DATE: March 16, 2024
TO: Greg Clarke, PE
FROM: Jim Buckman, PE
SUBJECT: Coors/St. Josephs Intersection Review
CC: Nancy Perea, PE; Margaret Haynes, PE

Parametrix reviewed the preliminary design of improvements to the NM 45 (Coors Boulevard) and St. Josephs Drive intersection in Albuquerque. The project will include improvements to the Coors/St. Josephs intersection and to St. Josephs Drive from Atrisco Drive to Coors. These improvements are necessary to accommodate increased traffic from proposed development west of Coors to the north and south of St. Josephs. The exhibits in the file, "24-02-02 Updated Roadway Exhibits.pdf" (Roadway Exhibits) by RESPEC Community Design Solutions were used for the detailed review. The design is approximately 30% complete, so not all details were available at this stage. The "Oxbow Development/Coors Pavilion (St. Josephs Dr./Coors Blvd.) Final Traffic Impact Study" (TIS), December 20, 2020, by Terry O. Brown, P.E. was also used for the analysis. The review focused on the improvements that would affect NMDOT facilities and traffic along Coors.

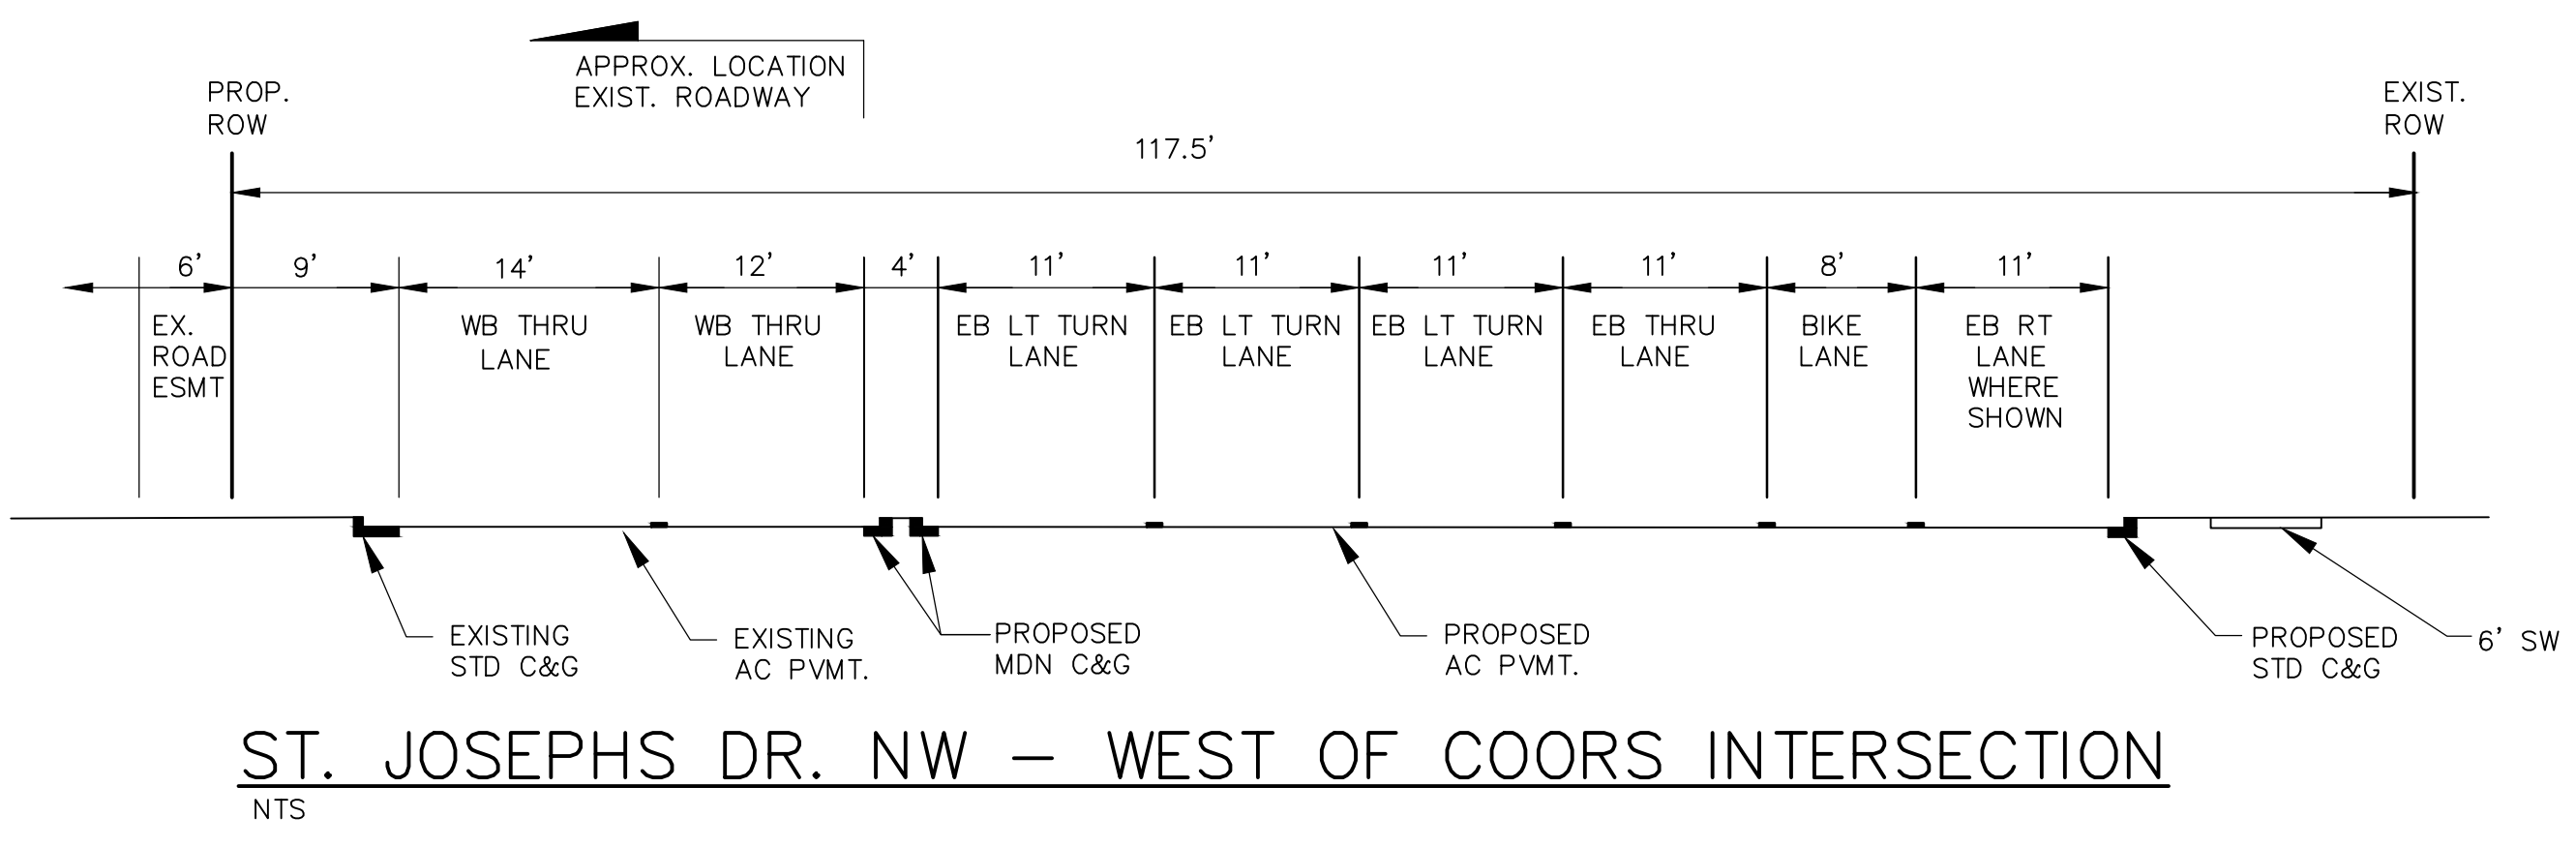
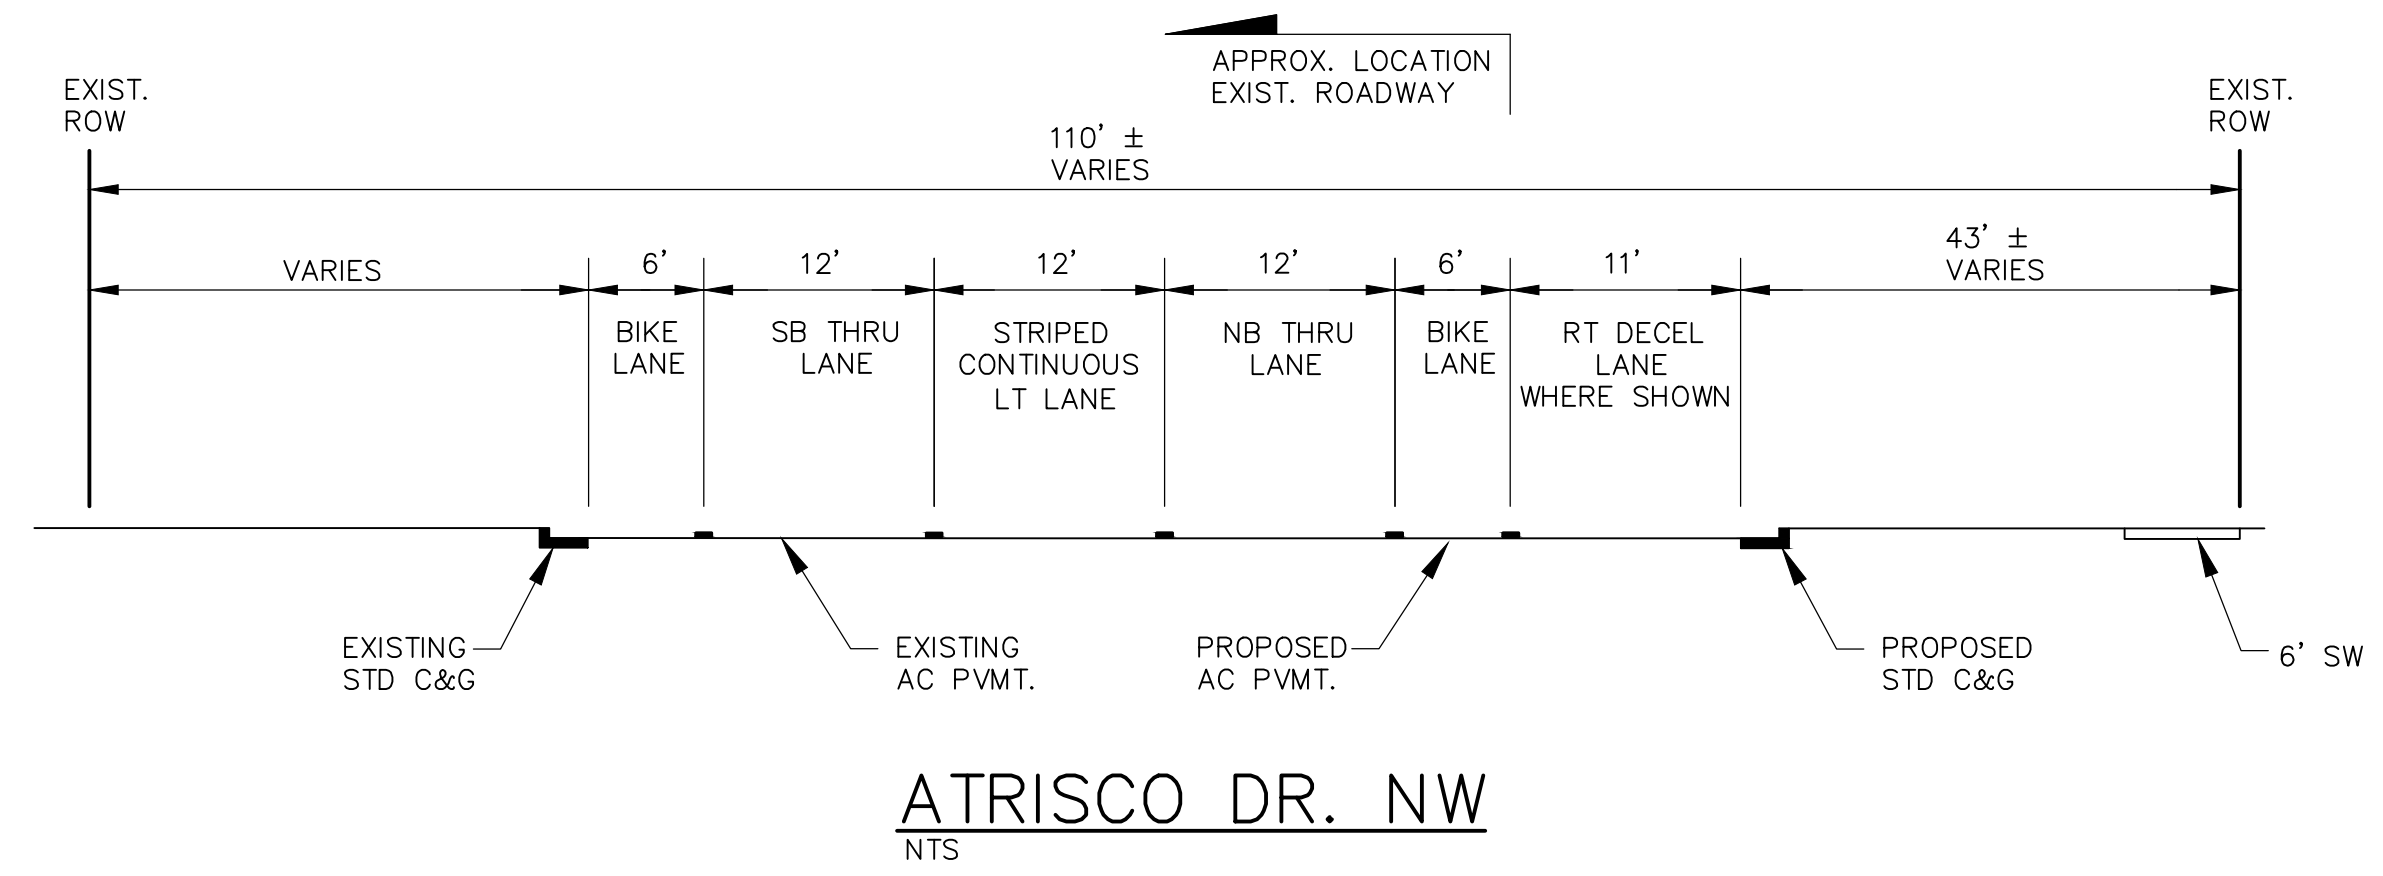
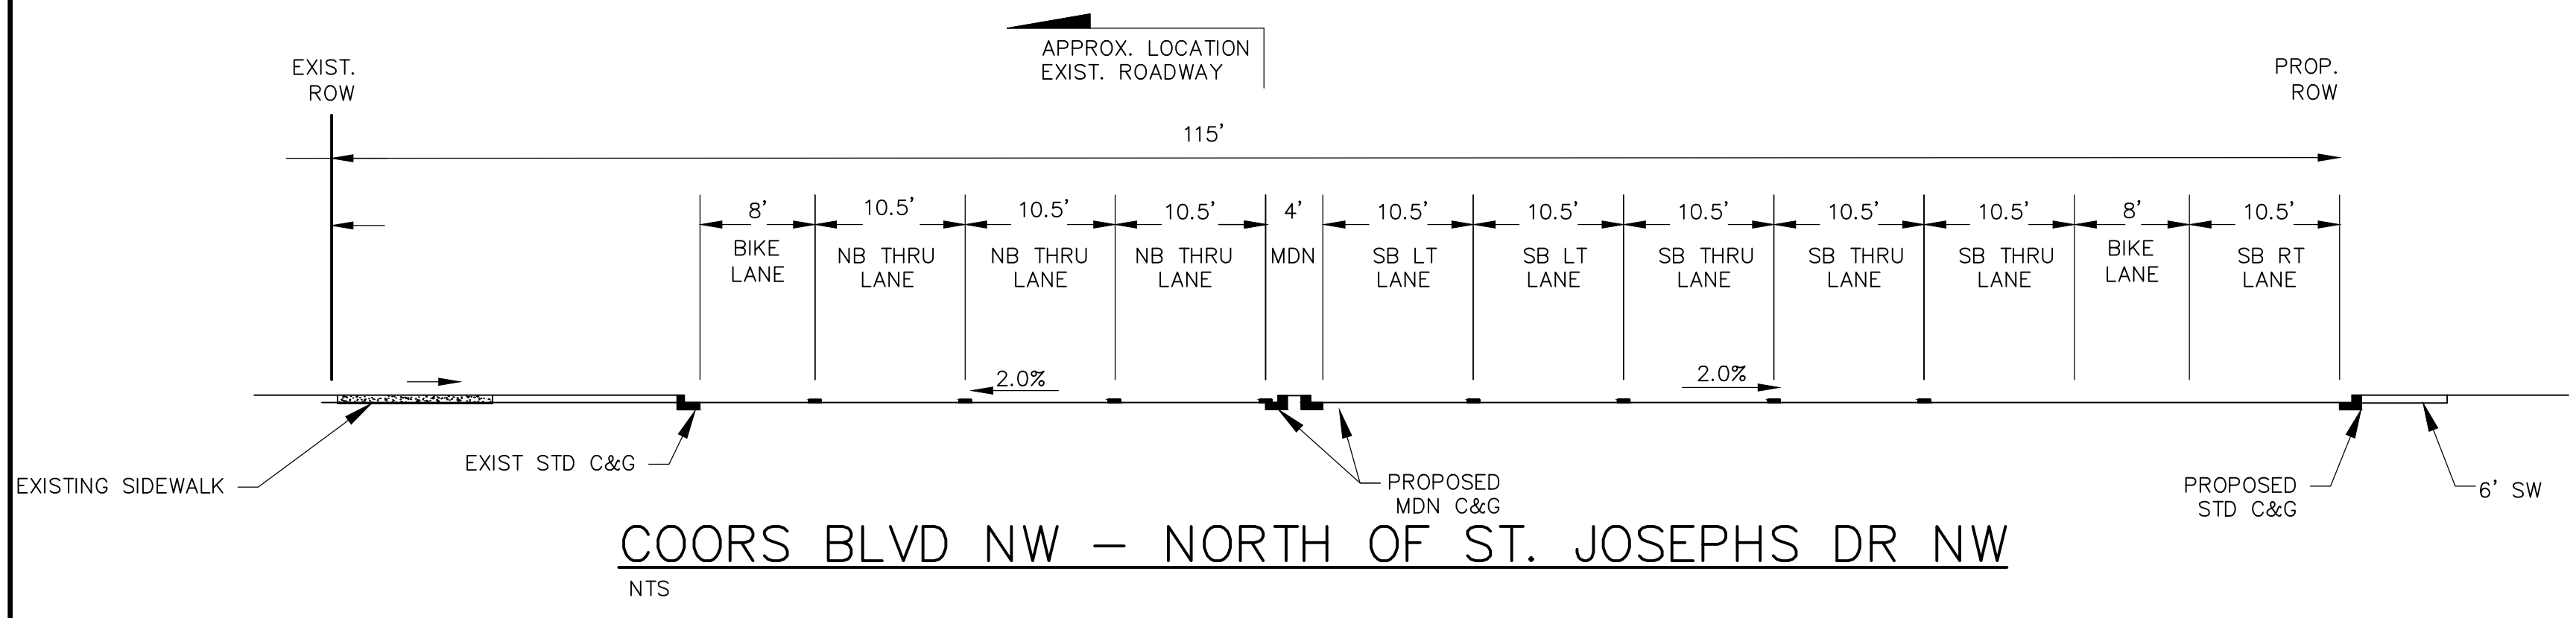
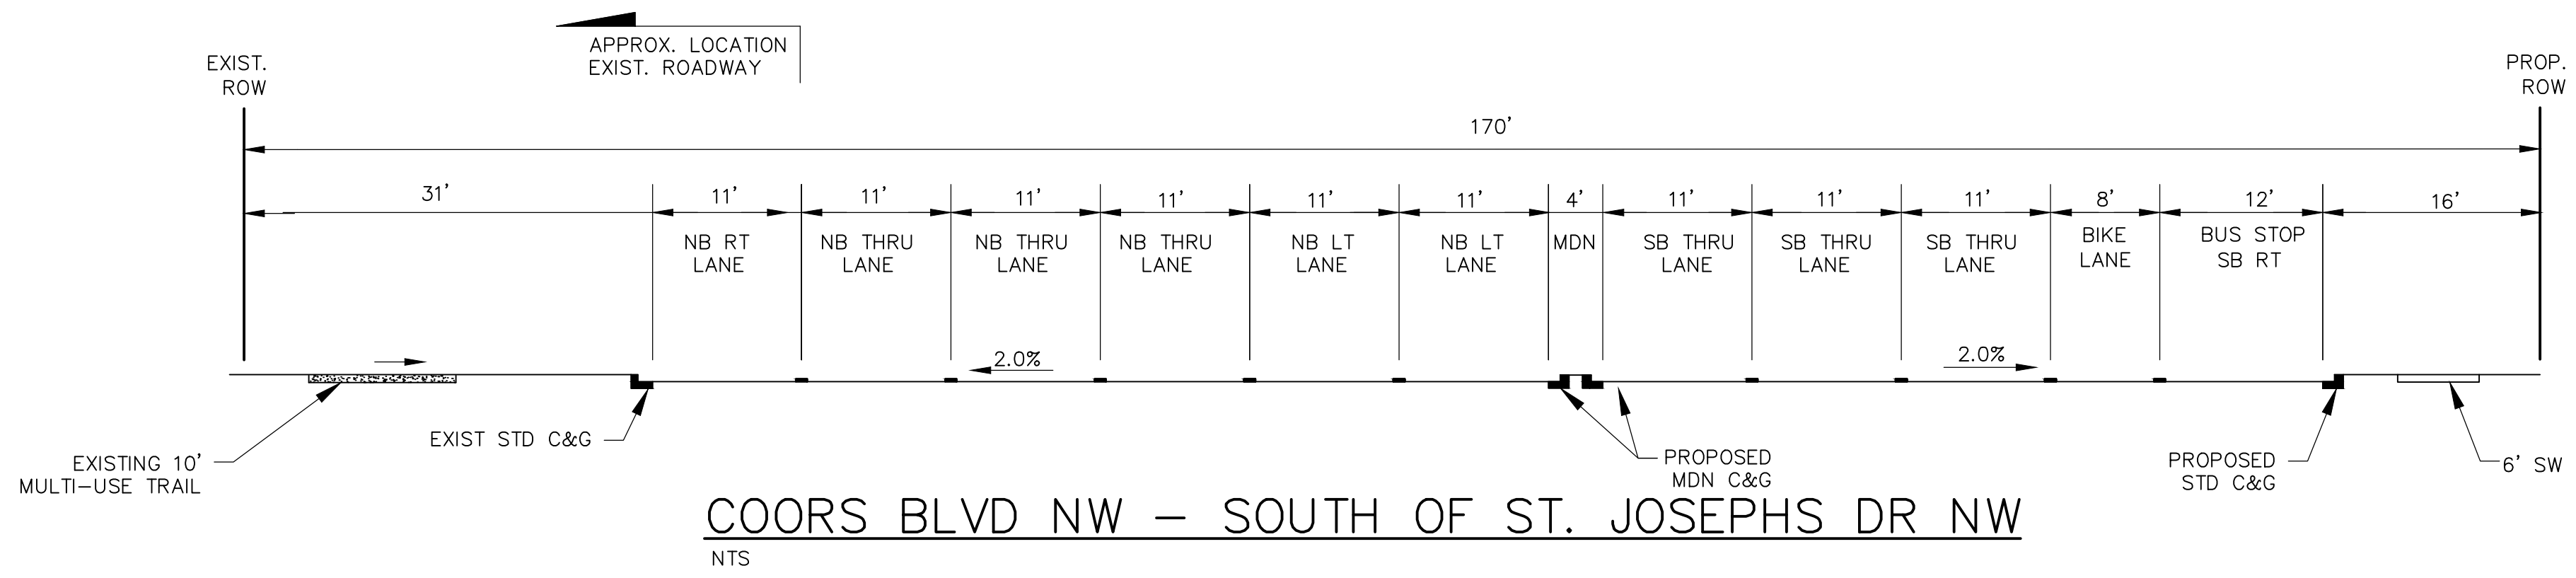
Several options are discussed below, along with their pros and cons. The options are conceptual, and further investigation would be needed before final recommendations are made. To illustrate some of the options, a conceptual plan and typical cross sections are attached. The conceptual layout assumes widening on both sides of Coors. This is per NMDOT standard practice, and it was helpful in identifying potential constraints and impacts. Note the preliminary design holds the existing curb on the east side of Coors. Other innovative design options also may be considered.

The preliminary design shows lane widths on Coors being reduced from 12' to 11'. This is a proven safety measure and should be retained in the proposed design.
